Your Ref: OWPC21911
Our Ref: BR/49/19/OUT 13-02-2019
Please ask for:
Mr S Davis

Outline application with all matters reserved for 22 No. new dwellings consisting of 2 No. 1 bed dwellings, 18 No. 2 bed dwellings & 2 No. 3 bed dwellings.

26 Burnham Avenue Bognor Regis

Roof / Site Plan (Proposed) 1:200

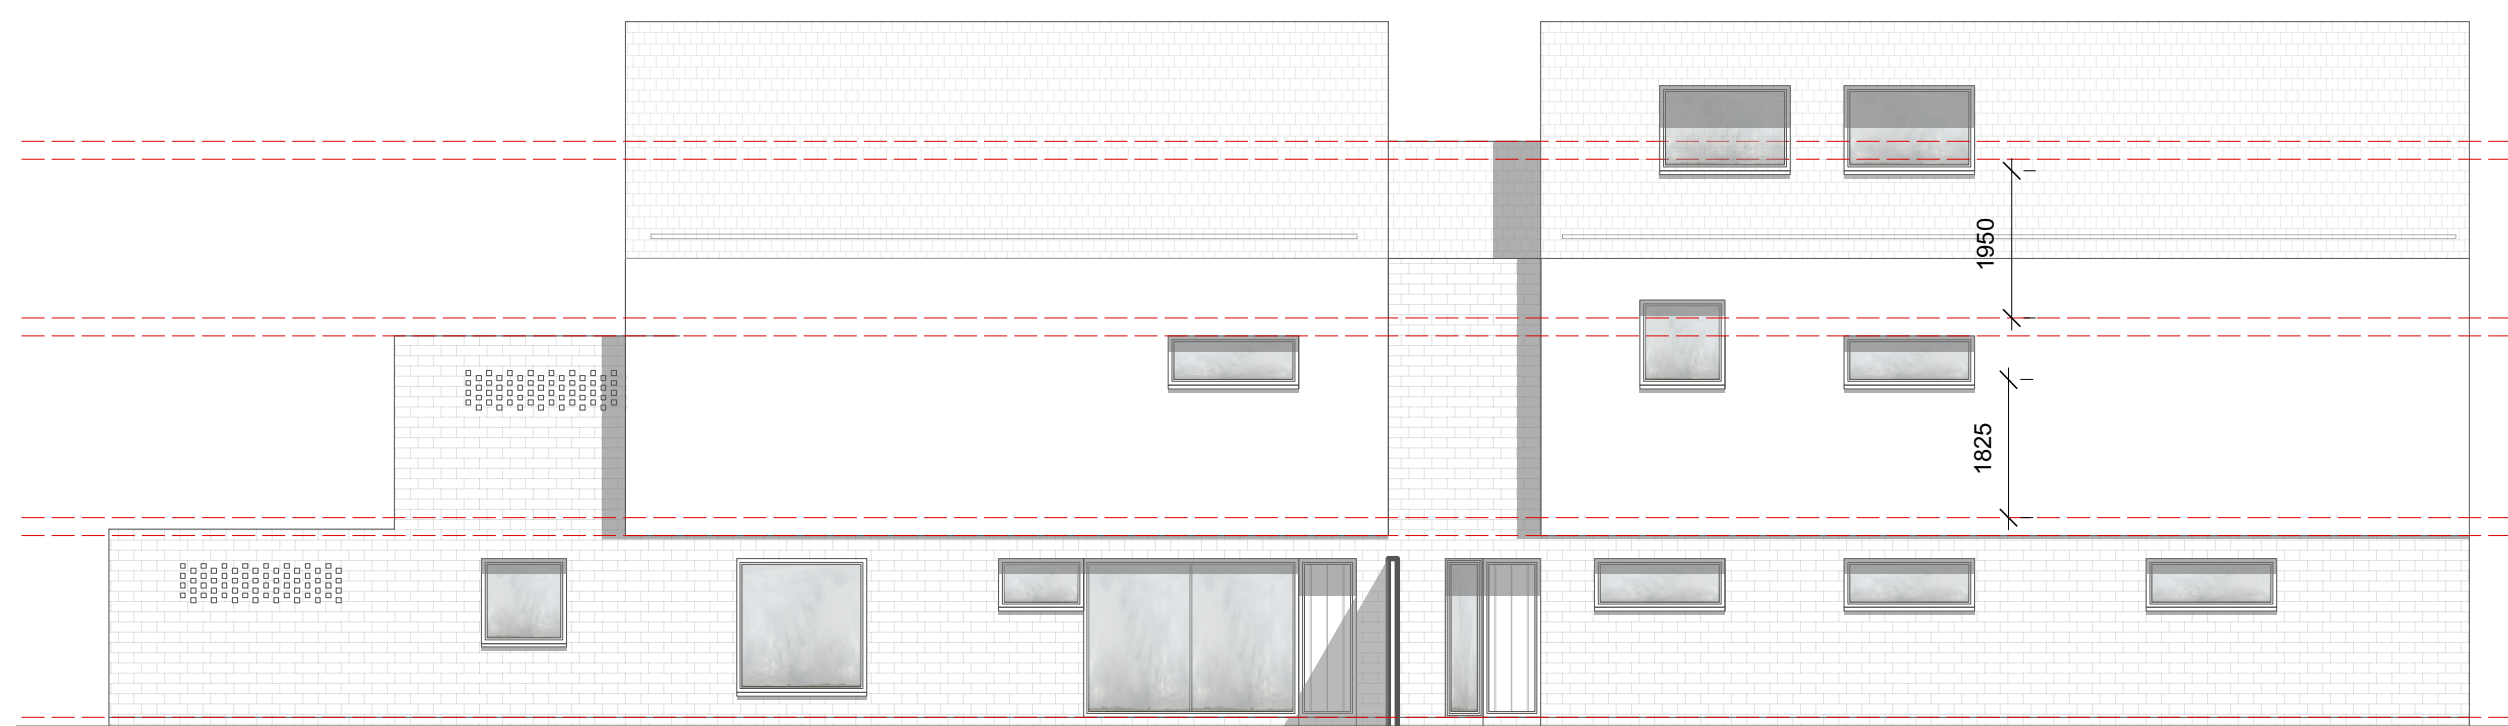
Very concerned about the impact on parking in the road which is already over used. The plan is for zero parking provision. This will not be enough and is unacceptable. This is a quiet residential area and this build will look overdeveloped and dominate the neighbourhood.
